Recommendation Report for Planning Permission for Works or Extension to a Dwelling

REF NO: BE/56/20/HH

LOCATION: Beech Cottage
99A North Bersted Street
Bersted
PO22 9AF

PROPOSAL: Conversion of roofspace to habitable use to include 2 x front dormers, 1 x rear dormer and 2 x front rooflights. This application may affect the setting of a Listed Building.

CLIENT	PROJECT	TITLE	STATUS	DRAWN BY	REVIEWED BY
C TOMKINS	REAR OF 99 NORTH BERSIED STREET	PROPOSED ELEVATIONS	PLANNING	SJ	SJ
			DATE	SCALE	DRAWING NUMBER
			24.06.2020	1:100@A3	17

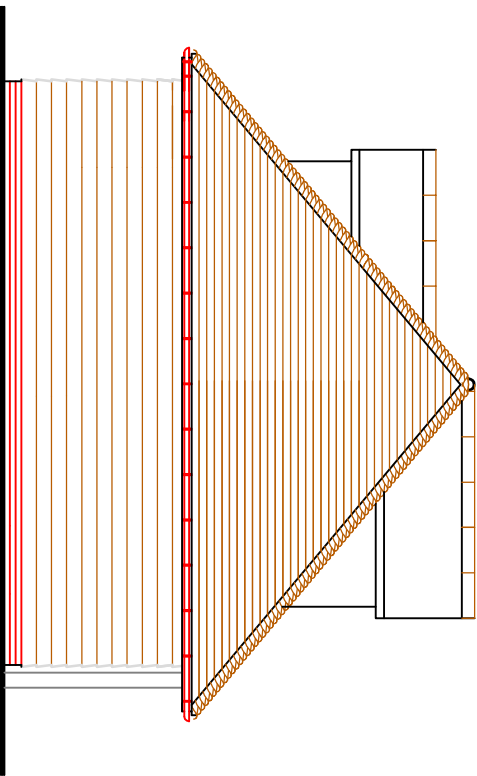
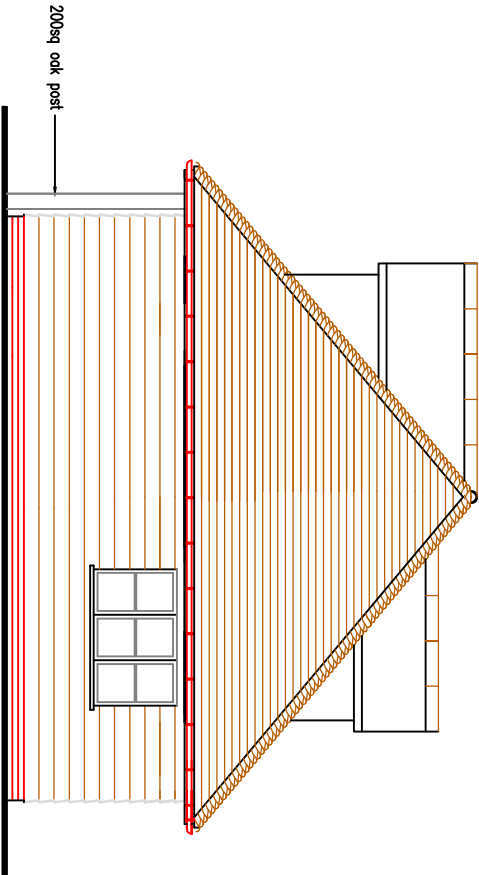
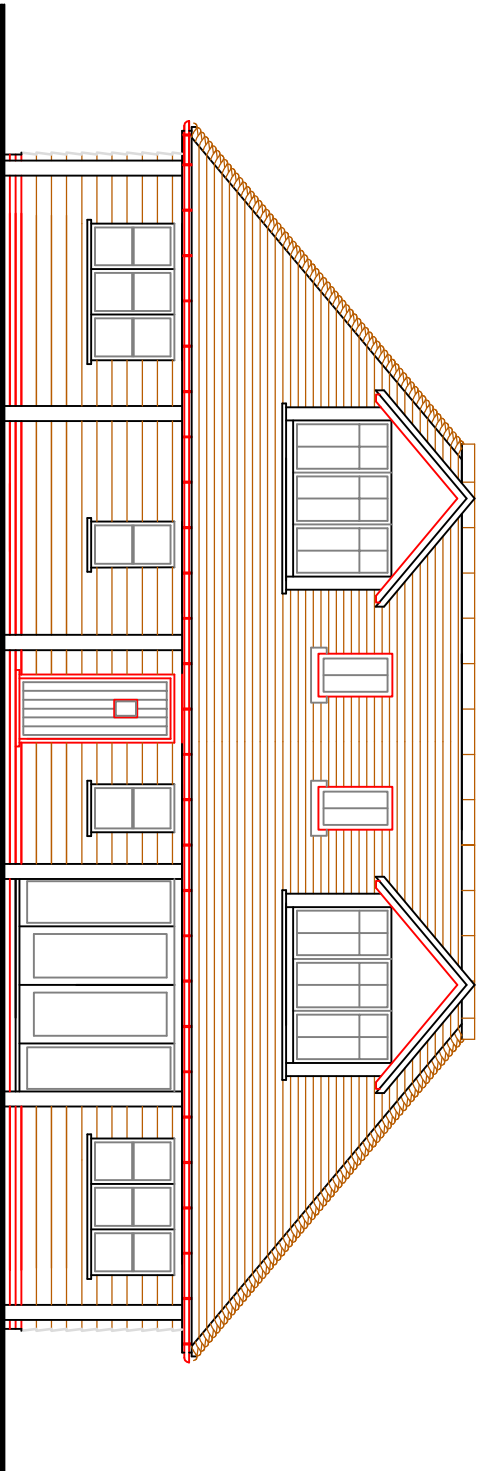
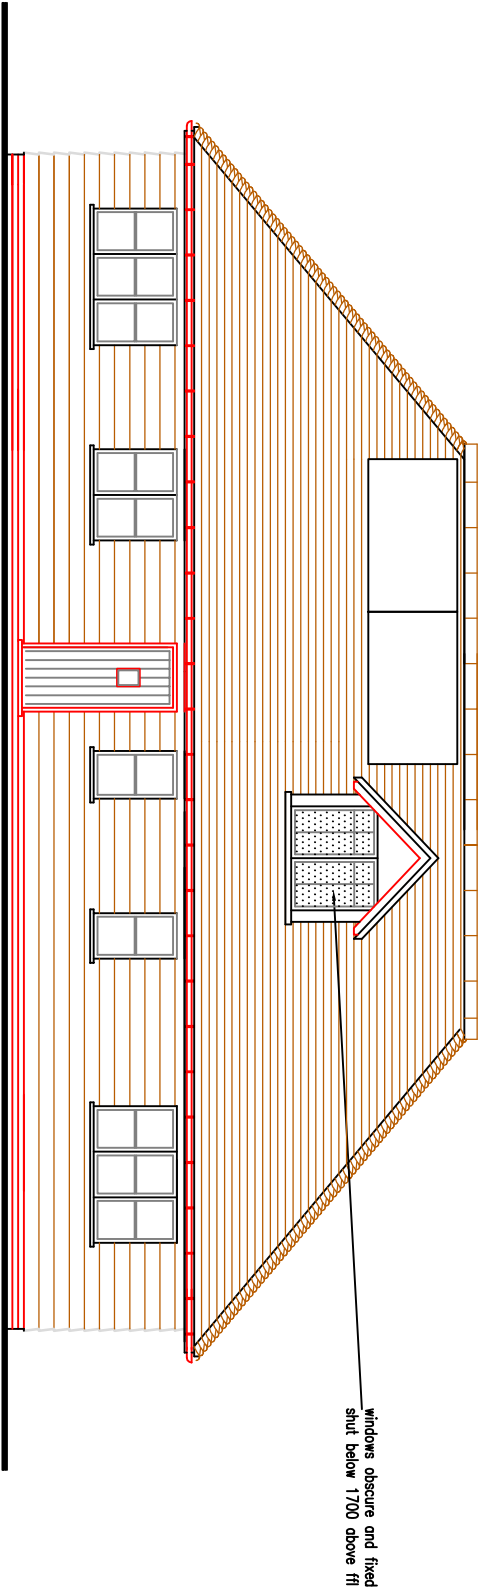
The proposal will construct three dormers with 2 to the front elevation which faces north west and 1 to the rear of the property.

The dormers to the front elevation have a height and width of 2.4m, with a depth of 2.85m. The dormer to the rear is slightly smaller. There will also be 2 rooflights to the front elevation.

There are no properties to the north west of the property and therefore the front facing dormers and rooflights will not give rise to adverse overlooking. The dormer to the rear will serve a bathroom and the property to the south east at No 99 is located sufficient distance away in such that there will be no direct views into the property. However, the dormer may give rise to views over the rear garden and as such will be conditioned to remain obscured glazed as demonstrated on the plan.

- Reason: In the interests of amenity in accordance with policies D DM1 of the Arun Local Plan.
- 4 The dormer window on the south east elevation of the building shall at all times be glazed with obscured glass and only openable at a high level, at least 1.7m above finished floor level.
